# CITY OF ALBUQUERQUE

November 23, 2011

**Re: Holiday Park Multigenerational Center Engineer's Stamp dated 10-21-11  
(G22/D008)**

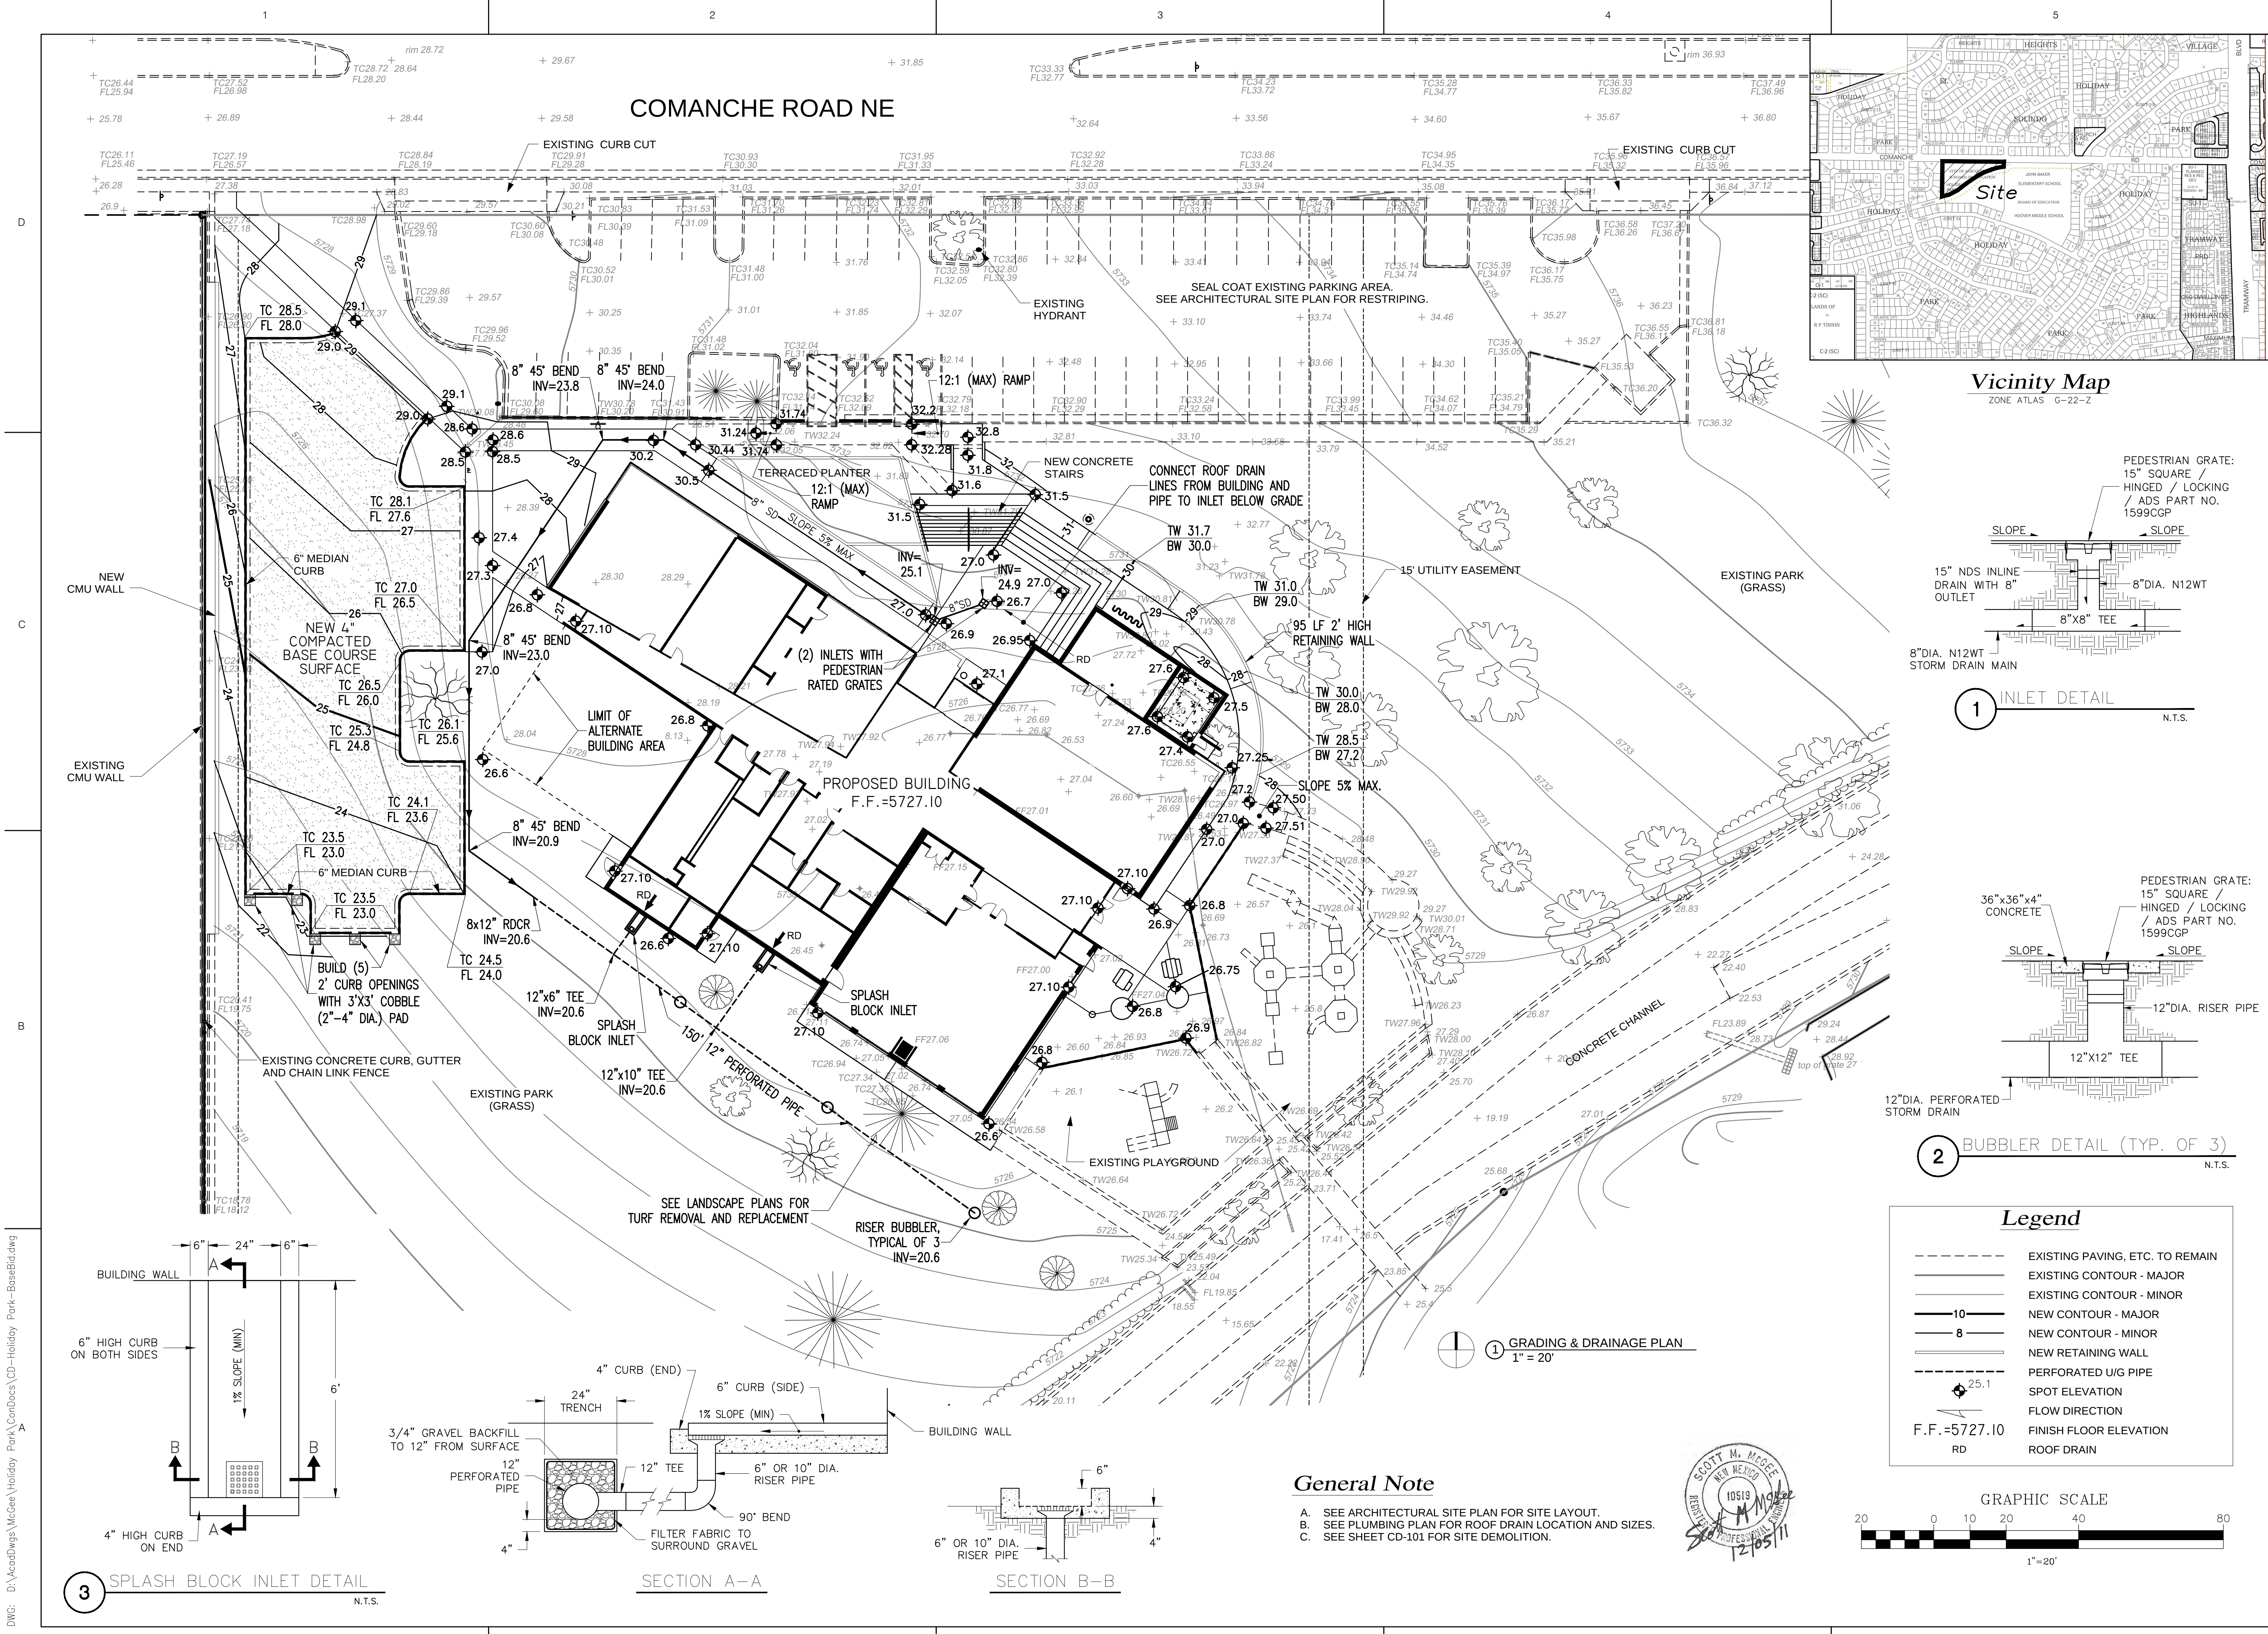
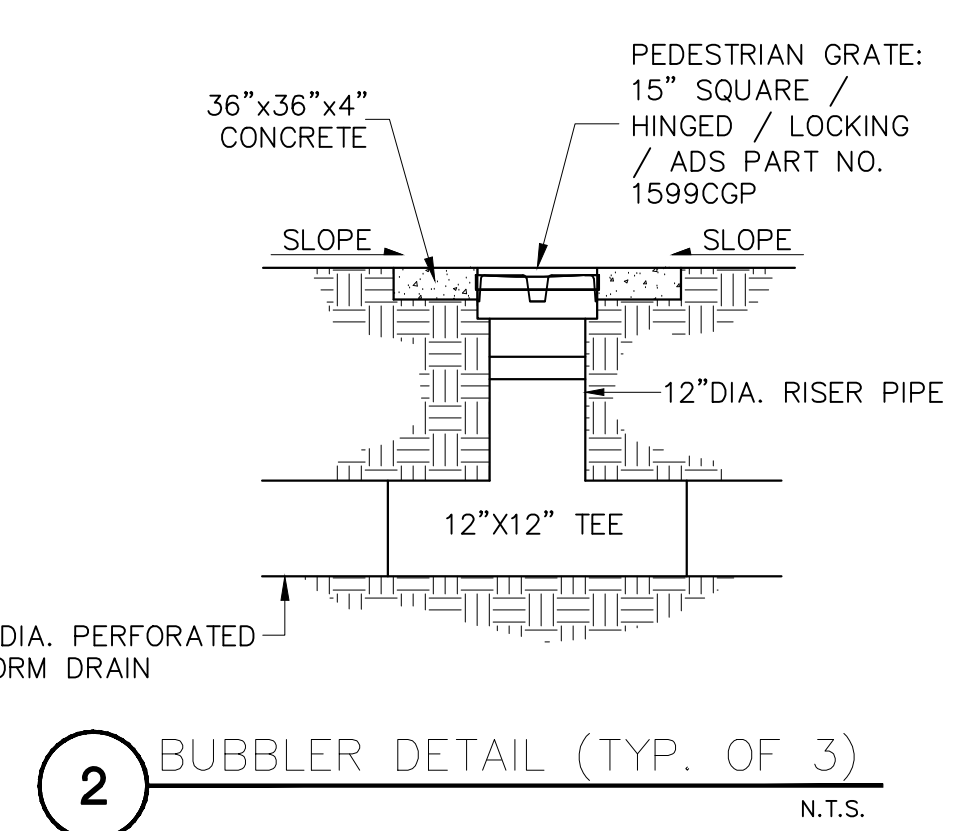
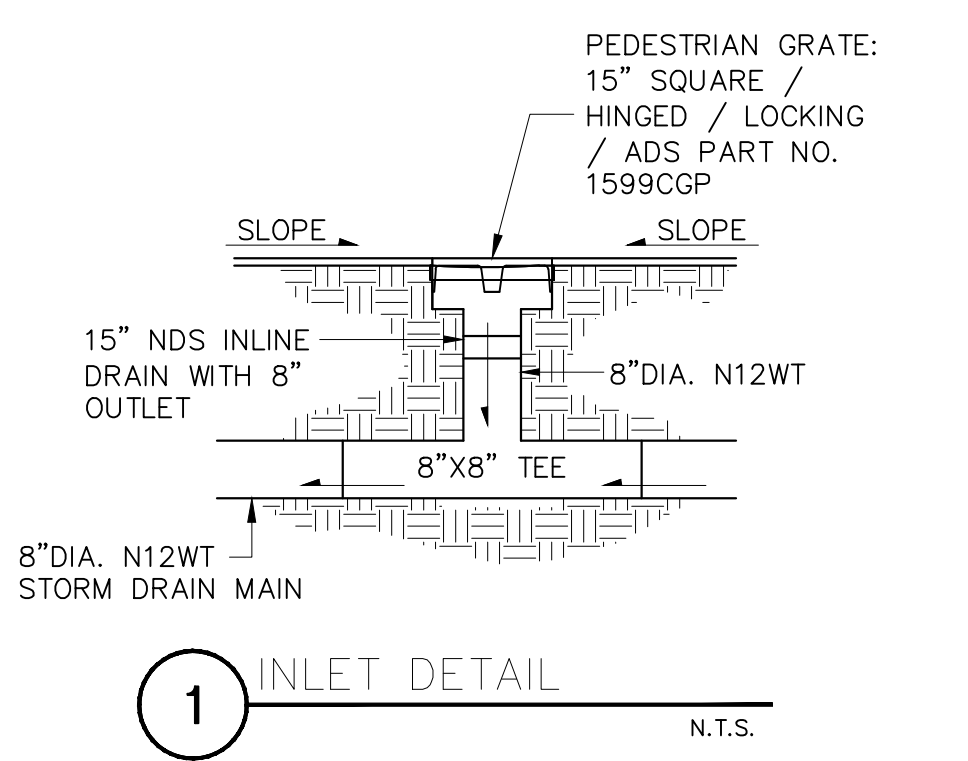
- Provide the amount runoff that drains to the north and to the south.
- How does the southerly portion of the site drain to the existing channel? If through an existing structure please provide location as well flow capacity calculations.
- Label existing contours.
- Show the limits of the existing drainage easement along the existing channel.
- Enlarge the vicinity map, and include a FIRM map.

Hydrology is requesting that proposed landscape areas be depressed to retain/infiltrate the rain that falls on them. If you have any questions, you can contact me at 924-3695.
